RETREAT AT TIMBERRIDGE FILING NO. 2
RESPONSES TO COMMENT LETTER DATED JULY 6, 2021
SF-21-021
OCTOBER 6, 2021

FINAL PLAT COMMENT LETTER

RETREAT AT TIMBERRIDGE  
FILING NO. 2  
JOB NO. 1185.20  
JANUARY 4, 2021  
SHEET 4 OF 7

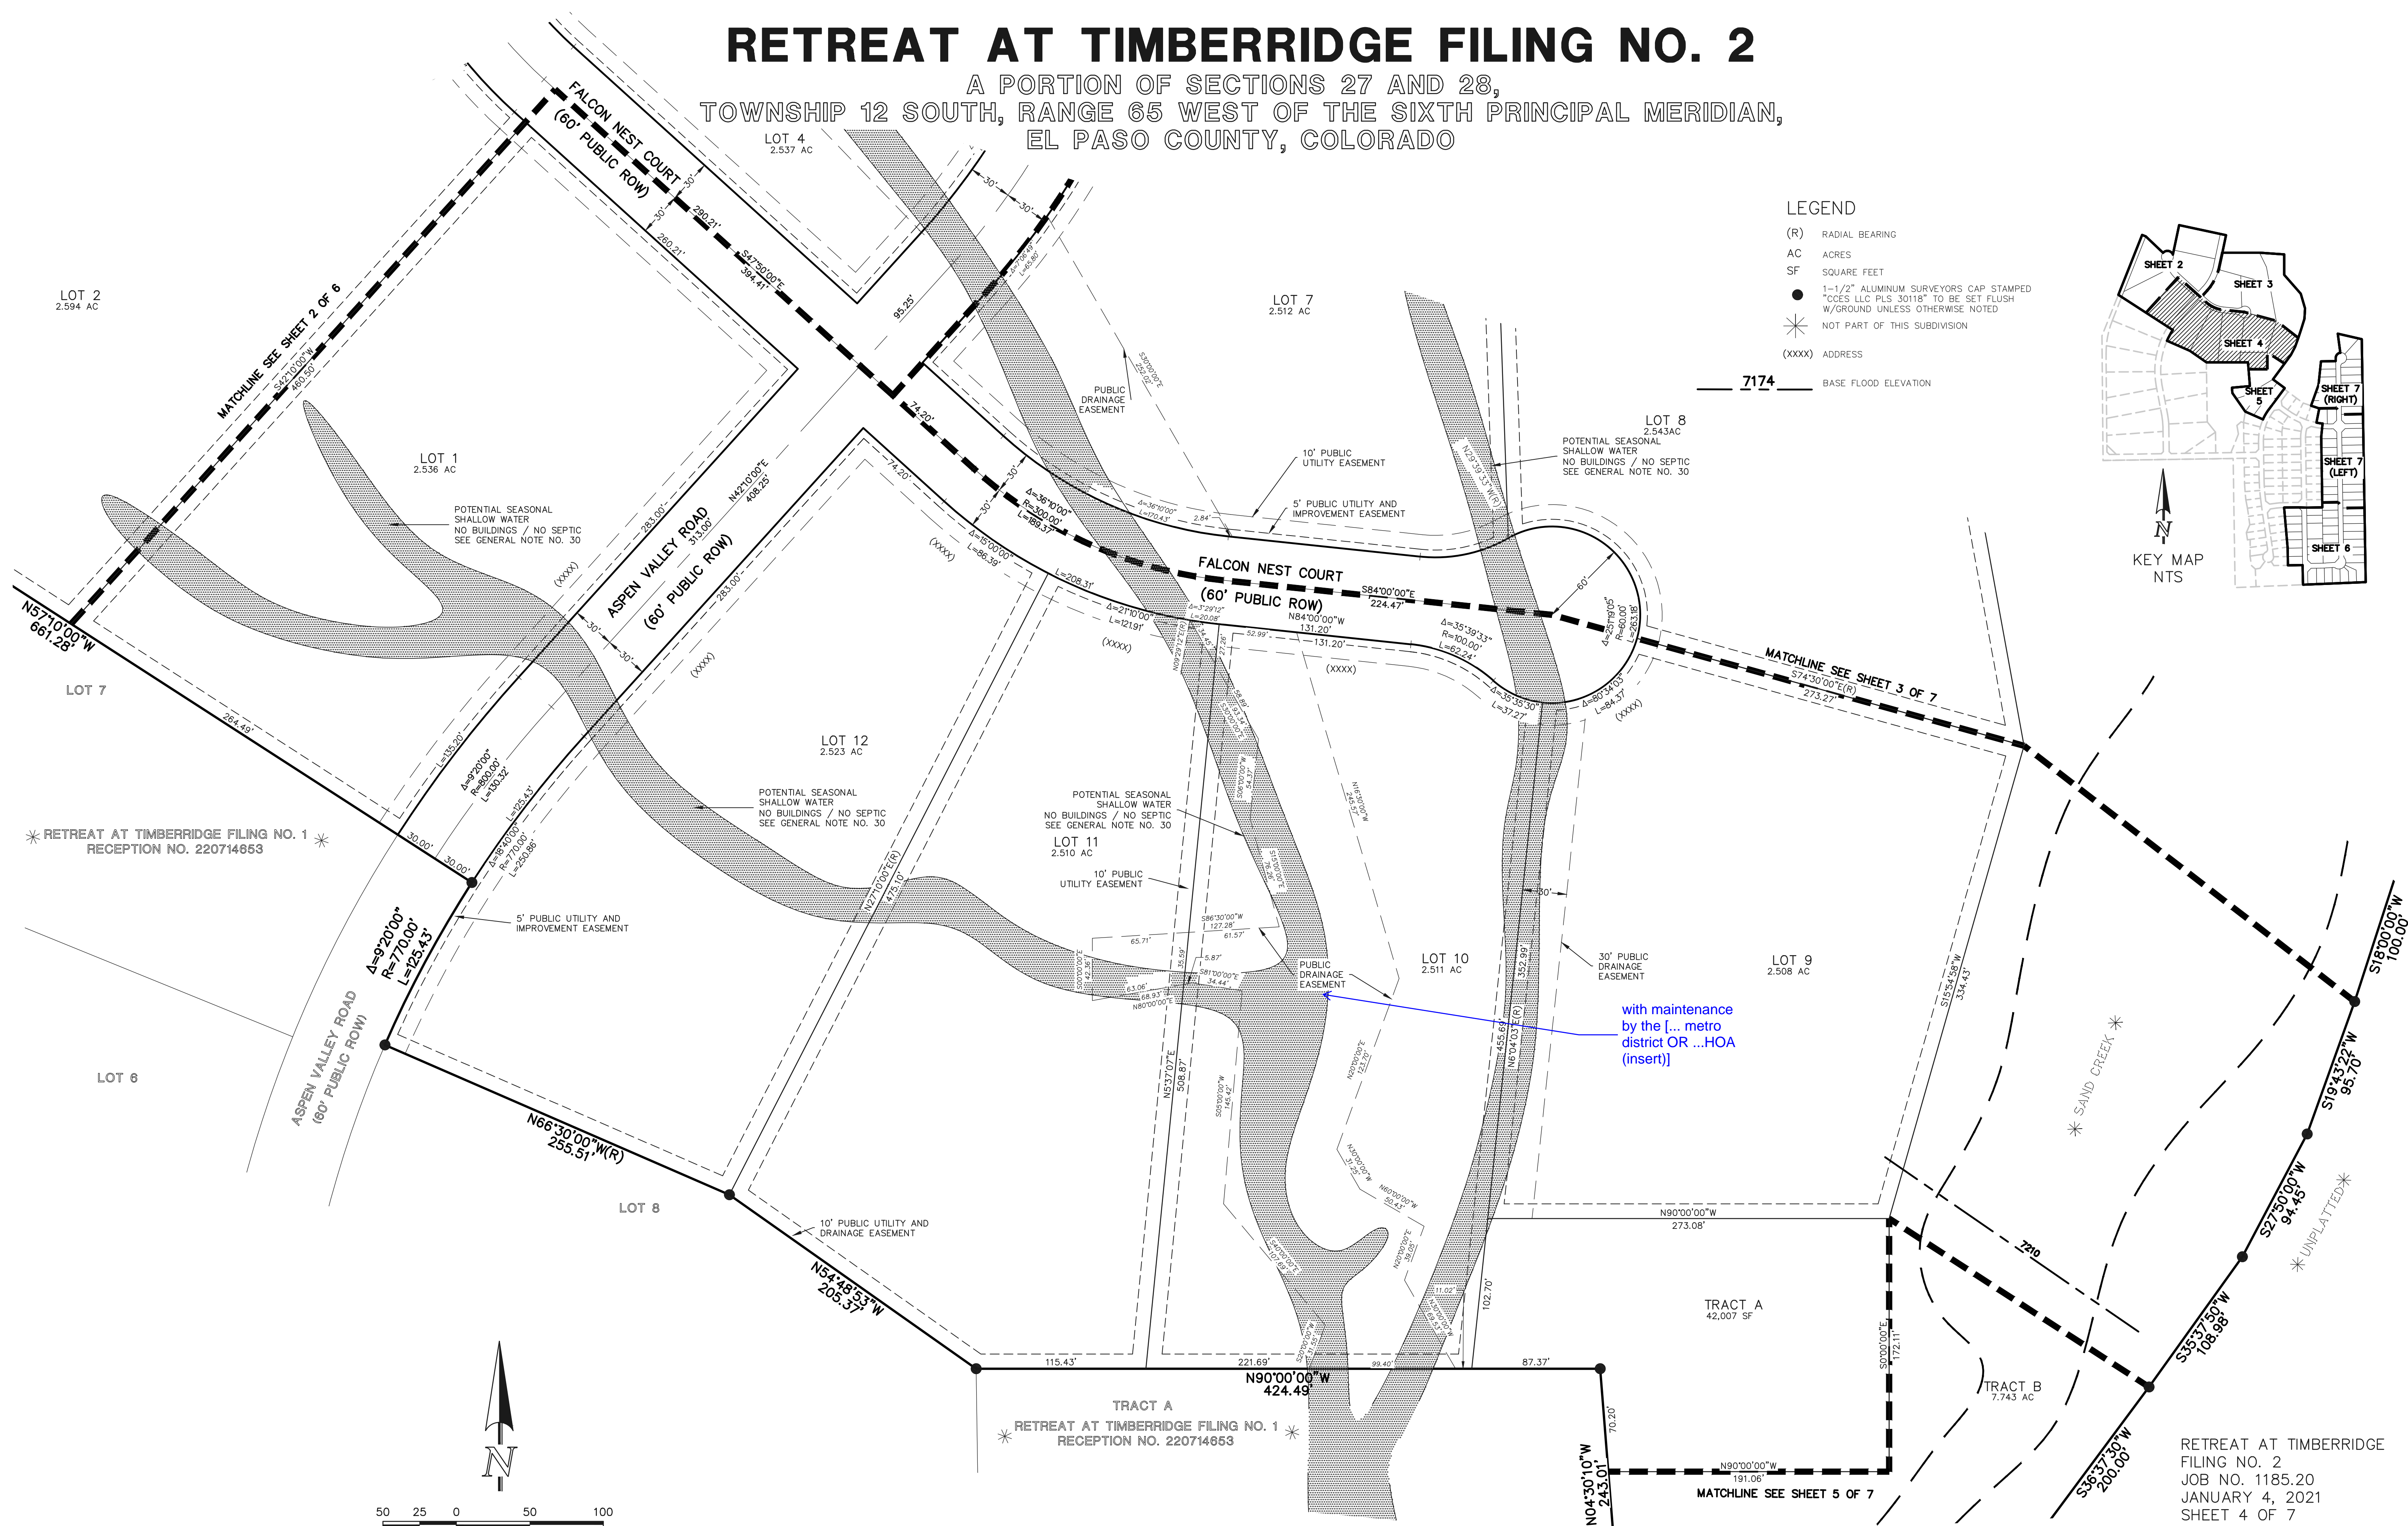
- THERE IS NO NEED FOR AN EASEMENT WITHIN THE TRACT (NOW TRACT B) AS THE TRACT WILL CONVEYED TO THE COUNTY AFTER ALL CONDITIONS STATED IN NOTE 23 ARE MET. THE DEVELOPER IS RESPONSIBLE FOR CONSTRUCTING THE TRAIL. THIS INCLUDED IN THE FAE UNDER LANDSCAPING IMPROVEMENTS.

RETREAT AT TIMBERRIDGE
FILING NO. 2
JOB NO. 1185.20
JANUARY 4, 2021
SHEET 2 OF 7

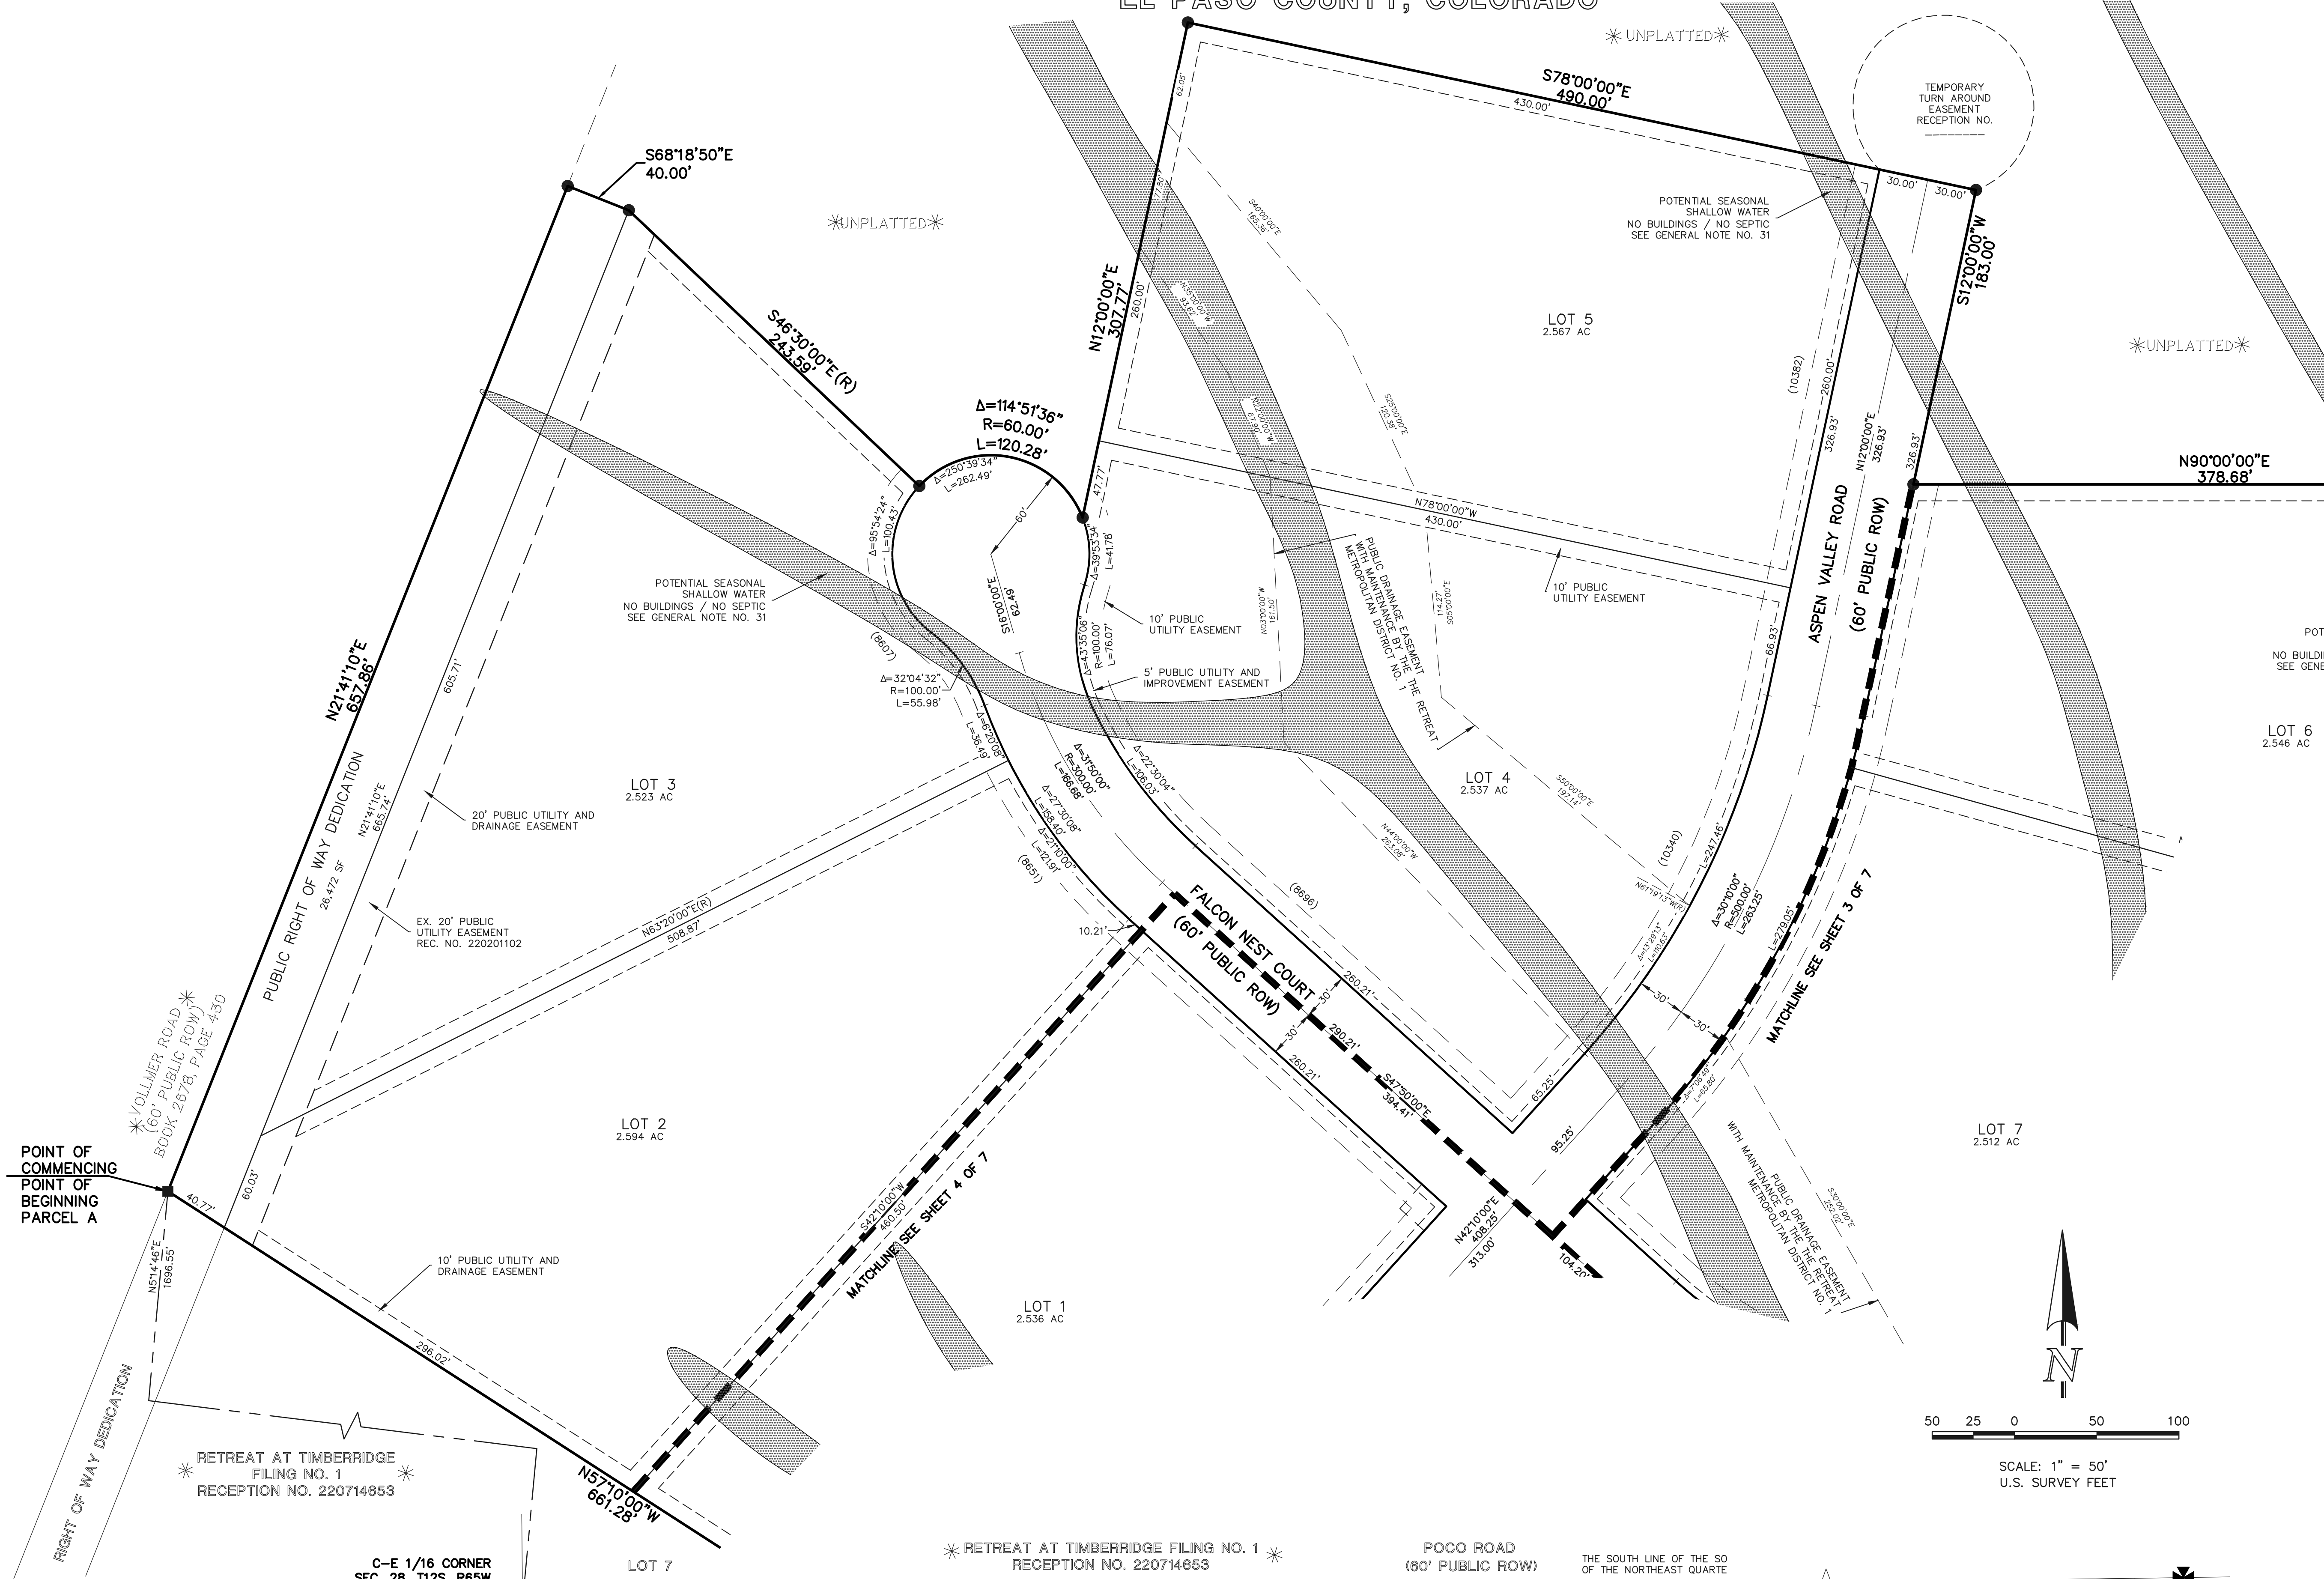
- THE TRACT "A" DESIGNATION HAS BEEN REMOVED AND "PUBLIC" ADDED TO THE RIGHT OF WAY DESIGNATION.
- THE FENCE IS IN THE FAE, PAGE 3, UNDER LANDSCAPE IMPROVEMENTS. NOTE 38 HAS BEEN ADDED REGARDING THE CONSTRUCTION AND MAINTENANCE OF THE FENCE.

RETREAT AT TIMBERRIDGE
FILING NO. 2
JOB NO. 1185.20
JANUARY 4, 2021
SHEET 3 OF 7

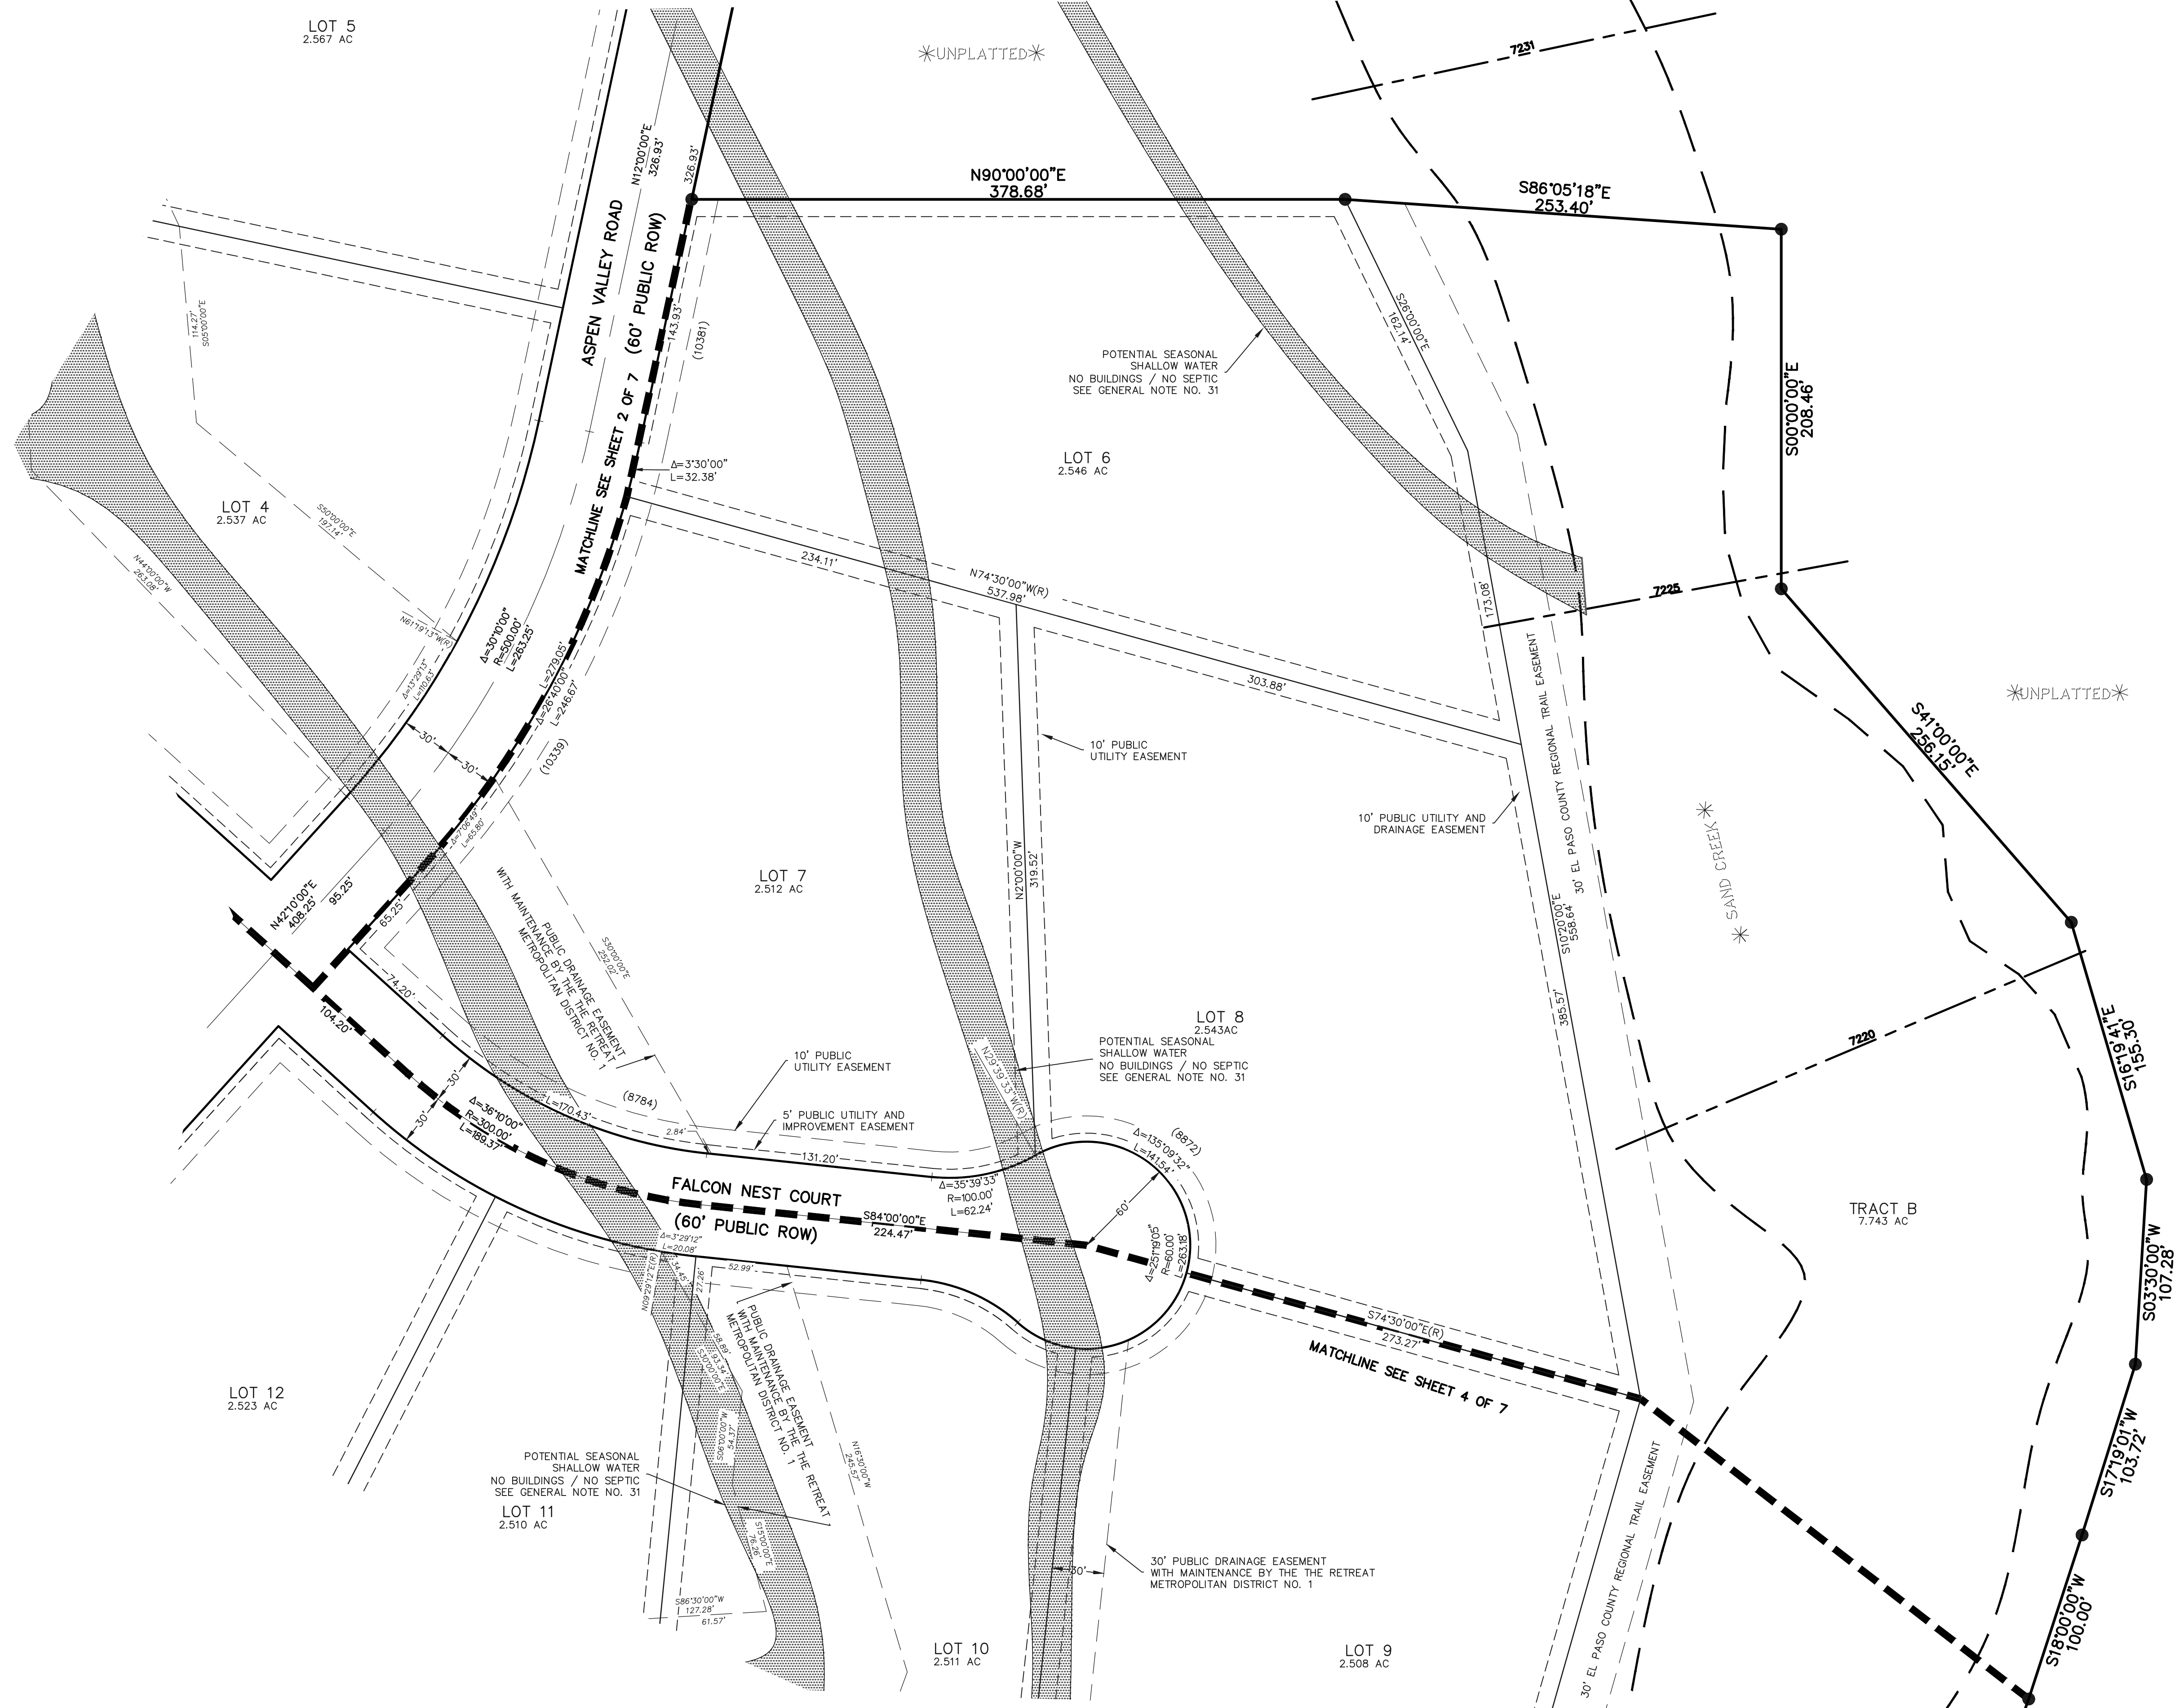
- THERE IS NO NEED FOR AN EASEMENT WITHIN THE TRACT (NOW TRACT B) AS THE TRACT WILL CONVEYED TO THE COUNTY AFTER ALL CONDITIONS STATED IN NOTE 23 ARE MET. THE DEVELOPER IS RESPONSIBLE FOR CONSTRUCTING THE TRAIL. THIS INCLUDED IN THE FAE UNDER LANDSCAPING IMPROVEMENTS.
